Engineers Comments Regarding Conditions 5 and 6

Application No: Y/183/21/DOC

Site Address: Pollards Nursery Lake Lane Barnham PO22 0AD

Description of Works: Approval of details reserved by condition imposed under ref Y/151/20/PL relating to Condition Nos 5 - surface water drainage and 6 - discharge flows to watercourses.

Drawing No.
6215 - DR11

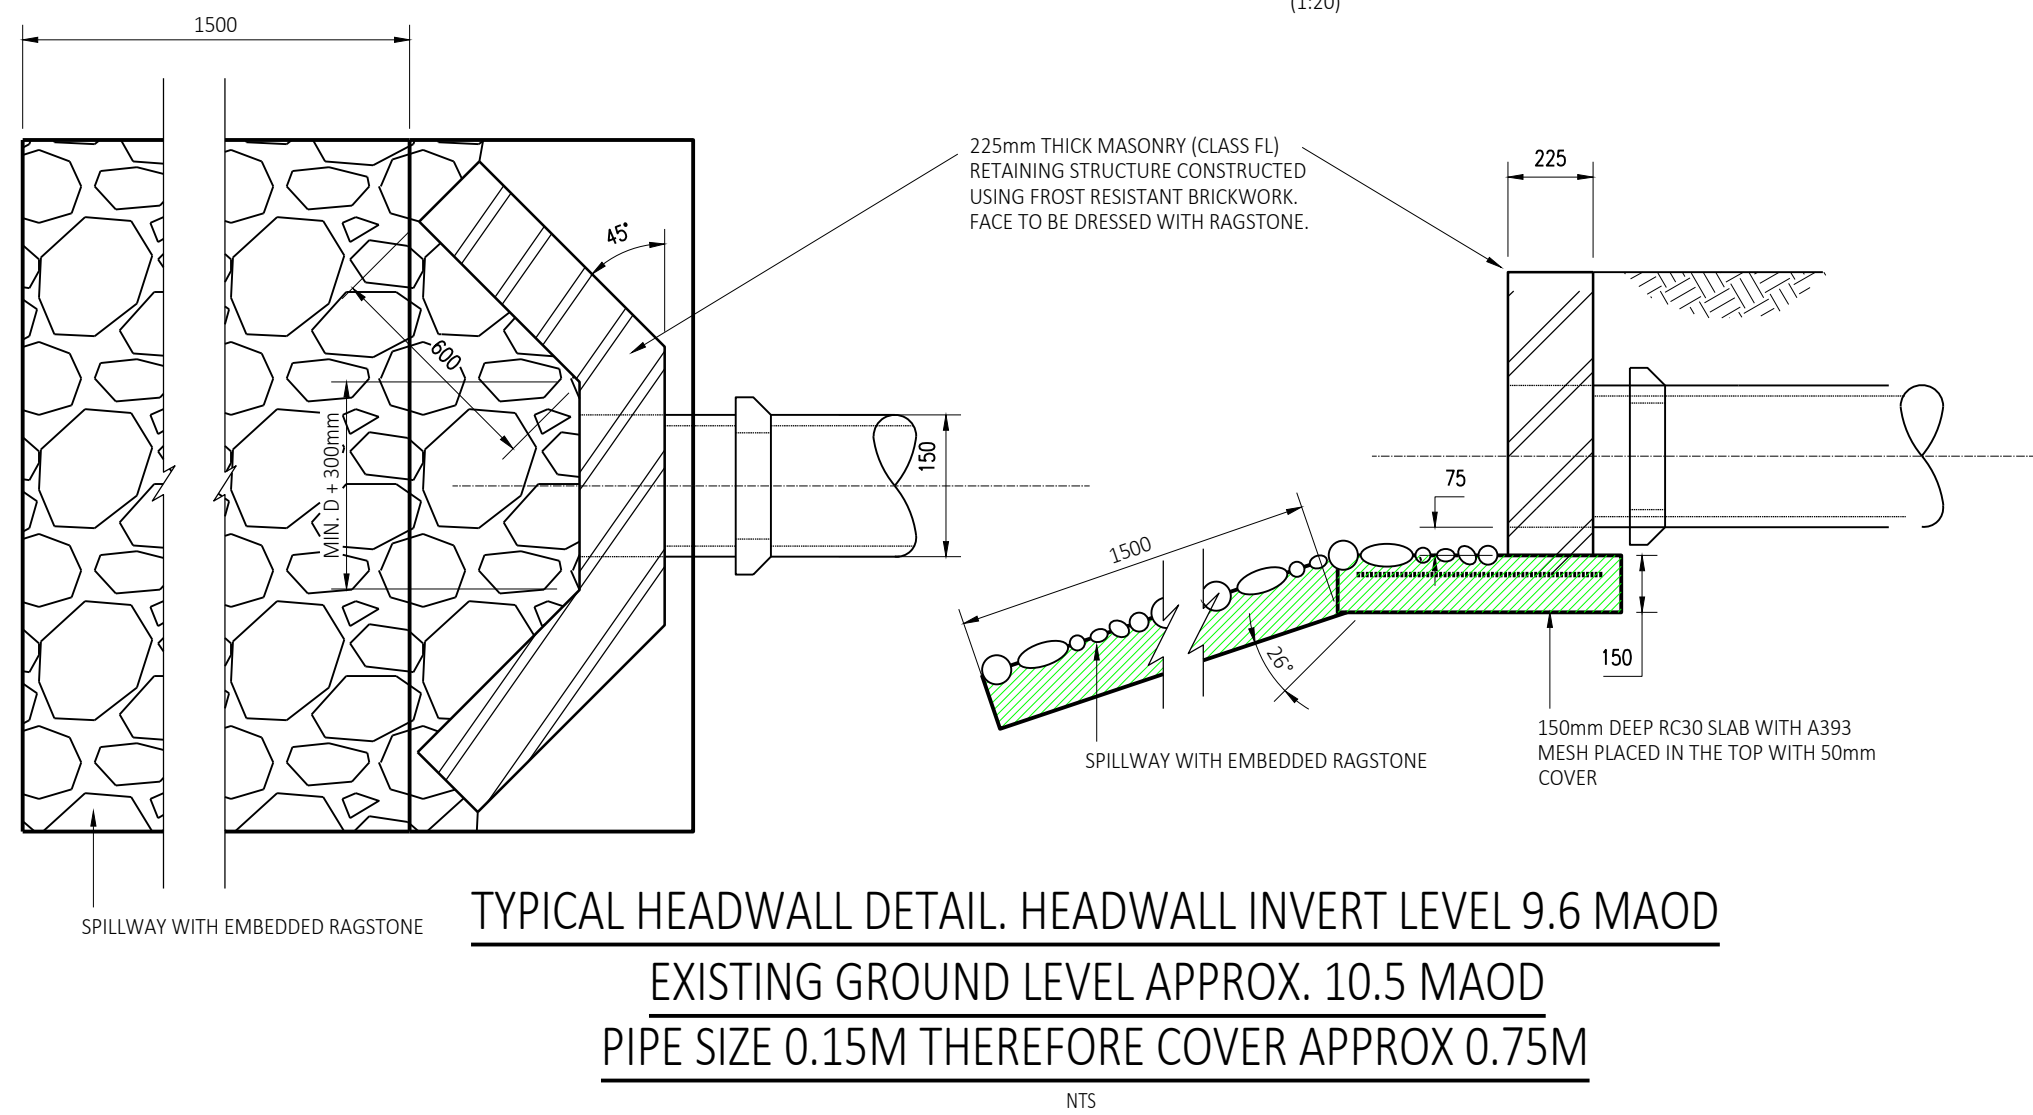
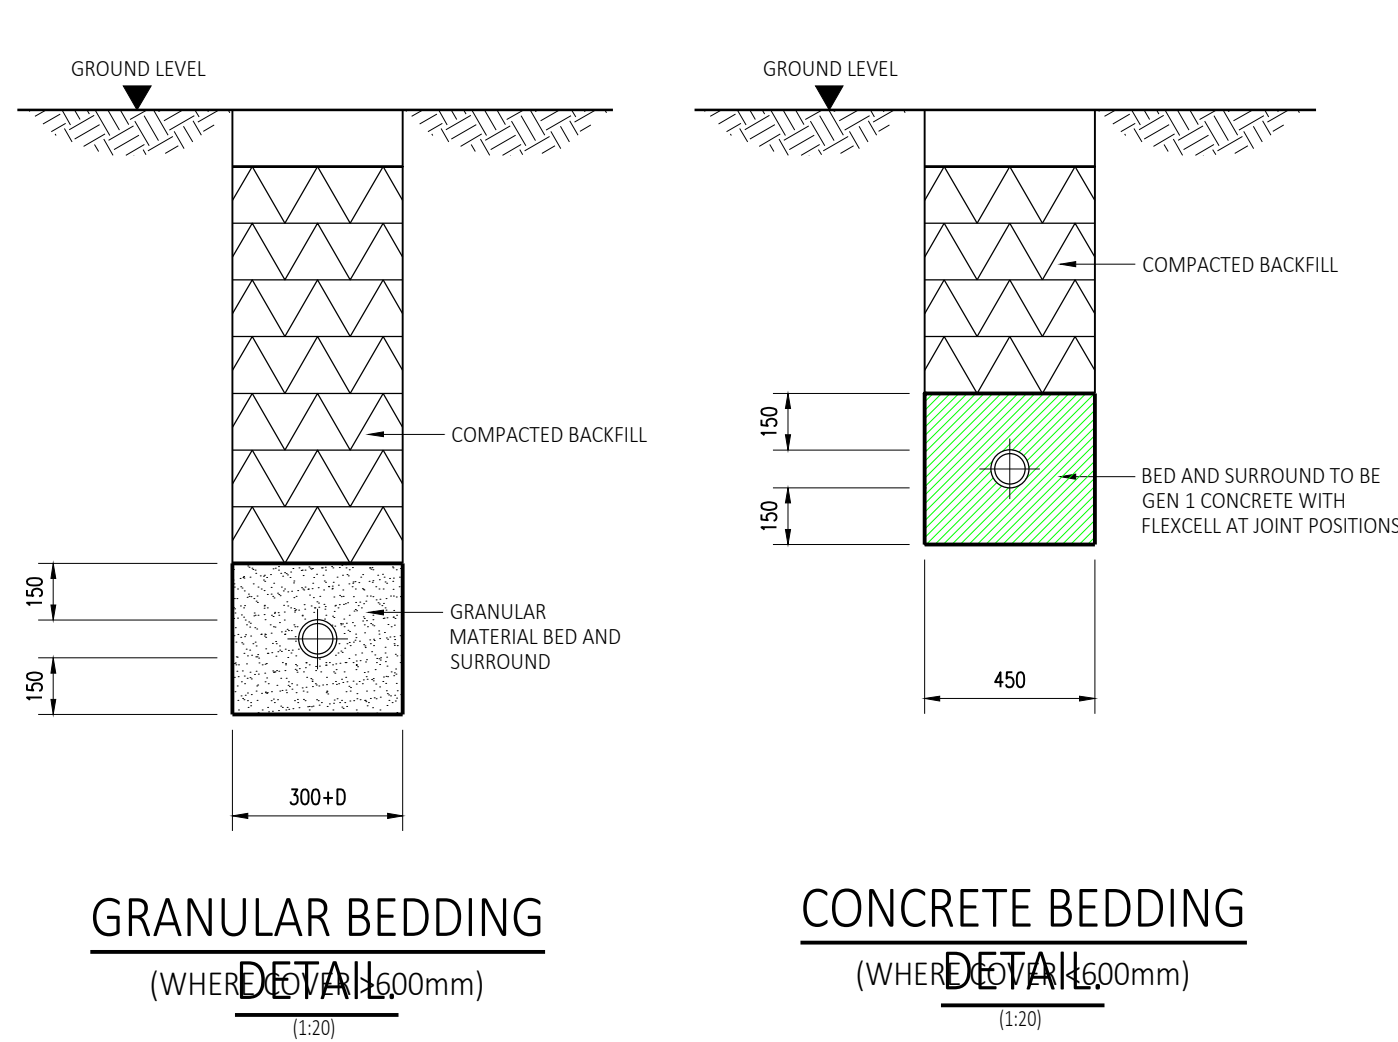
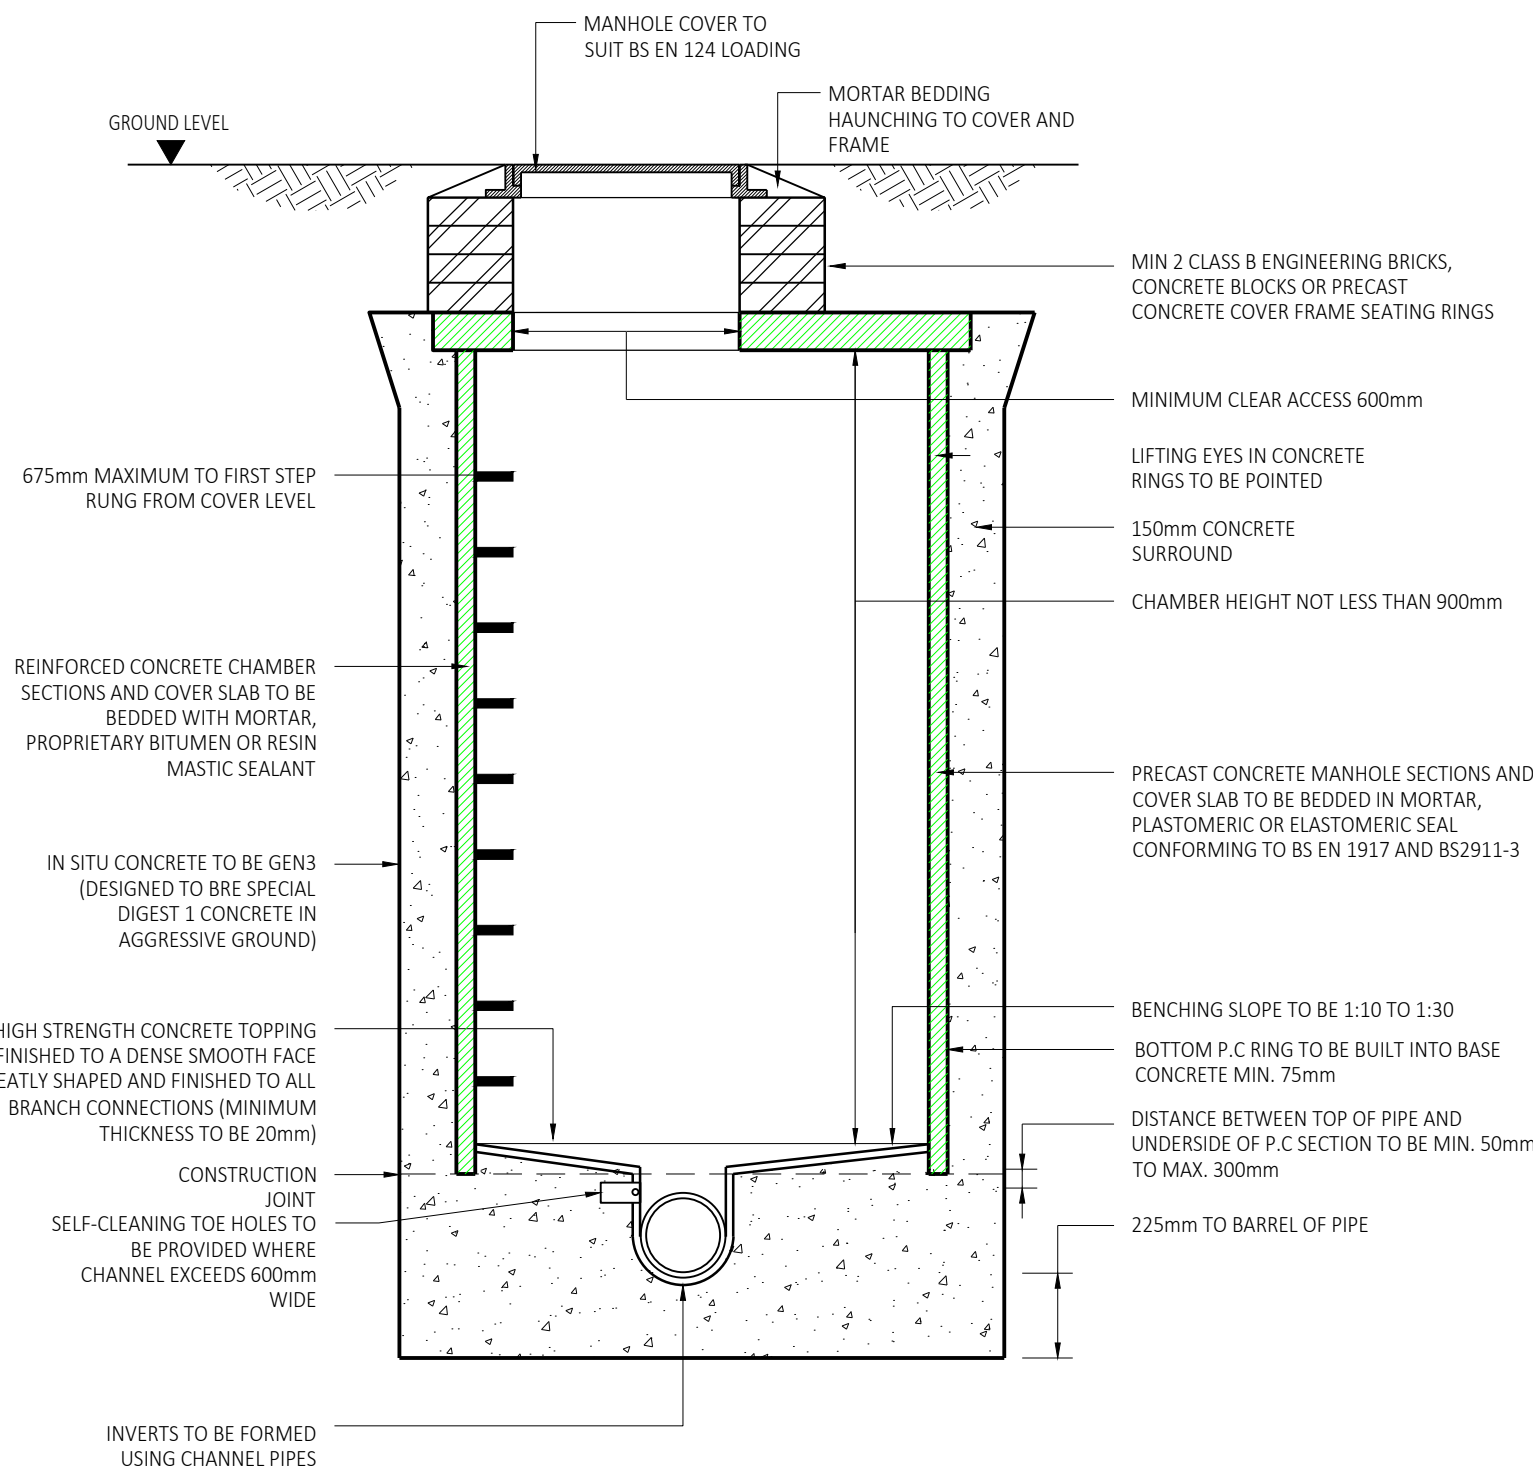
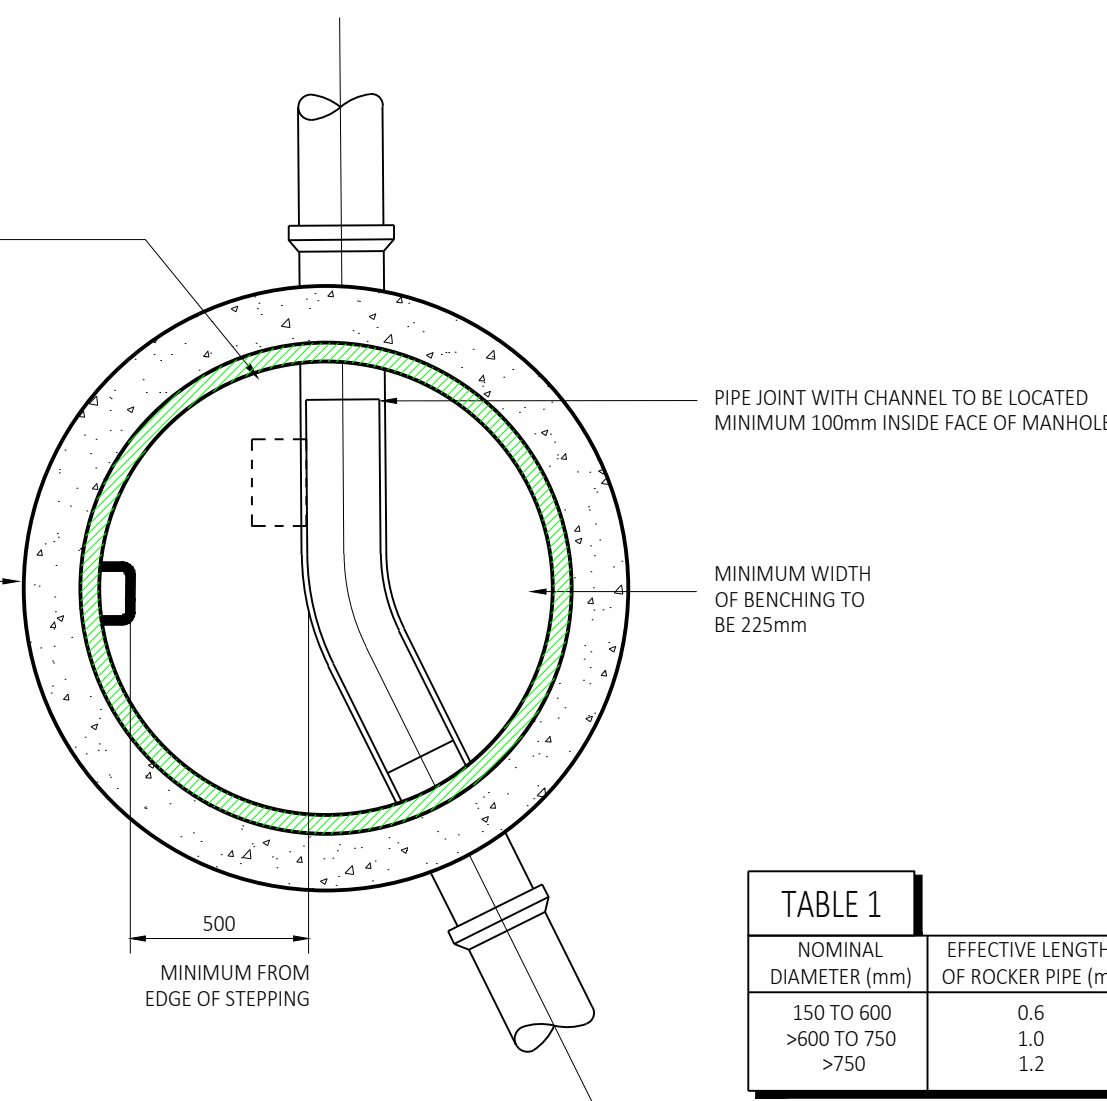
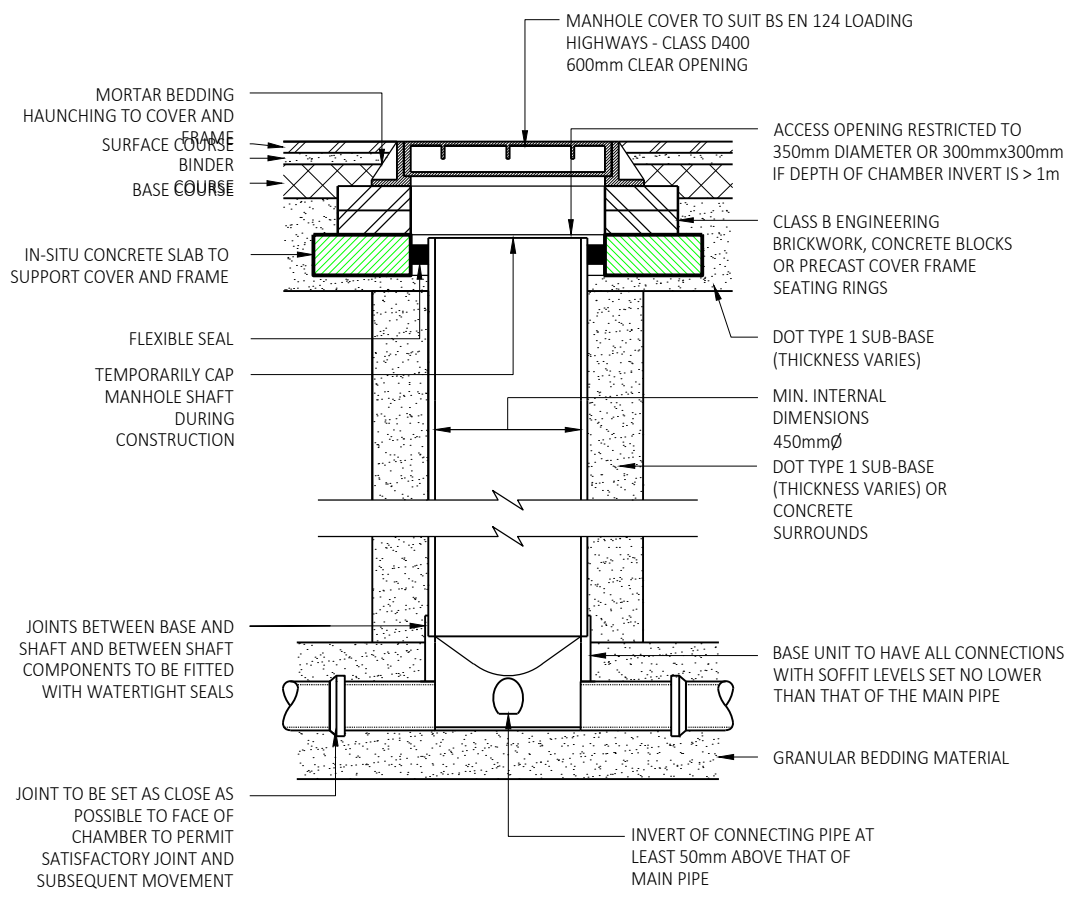
We recommend discharge of conditions 5 and 6. Please ensure the following are listed in any approval:

6215-DR11 Rev B Foul and Storm Drainage

Please note that should the land drainage consent process require changes to either of these drawings that a new discharge of conditions application will be required.
